WEST SUSSEX COUNTY COUNCIL CONSULTATION

TO:	Arun District Council FAO: Anita Gardner
FROM:	Alison Meeus, WSCC
DATE:	25/09/2018
LOCATION:	Duke Street, Littlehampton
SUBJECT:	<u>LU-246-18</u> Former Tap and Barrel,P.H
DATE OF SITE VISIT:	n/a
RECOMMENDATION:	☐ Advice ☐ Objection ☐ Modification ☒ No Objection ☐ More Information ☐ Refusal
S106 CONTRIBUTION TOTAL:	£ See below for breakdown.

Discharge of condition 7 – covered and secured cycle parking

Ground Floor - General Arrangements

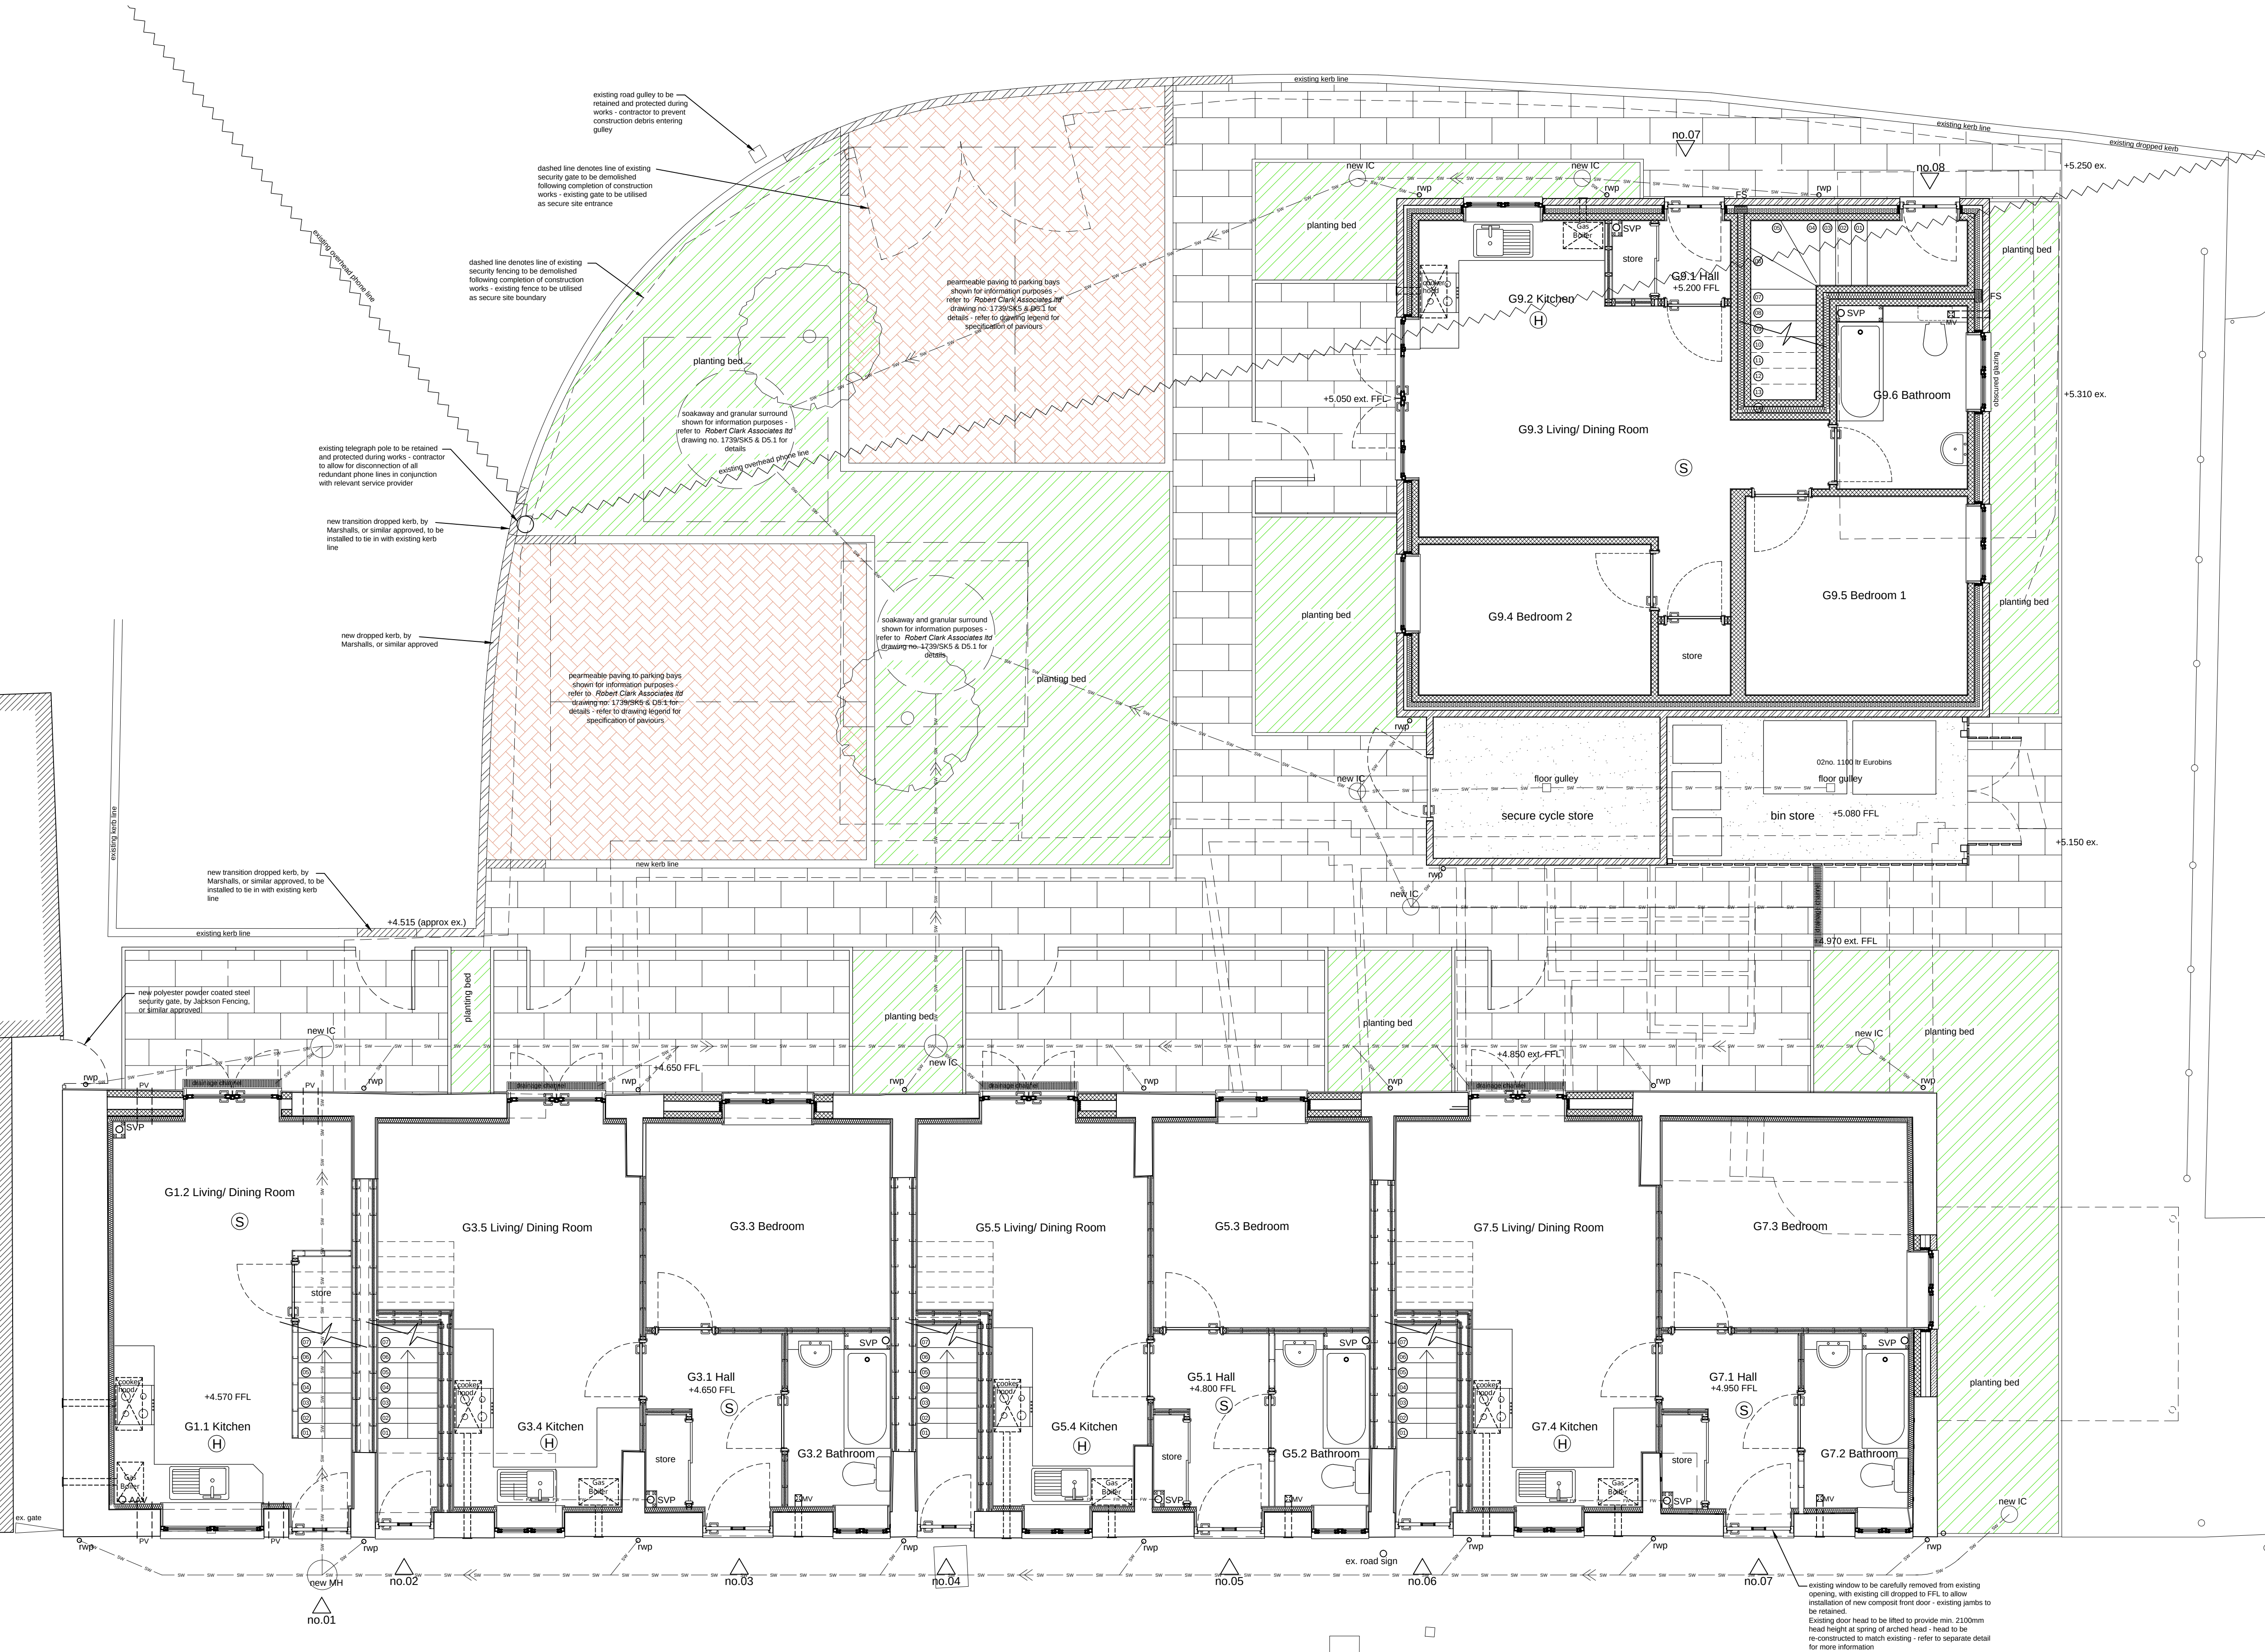
Cycle storage is proposed in designated cycle store. Condition discharged.
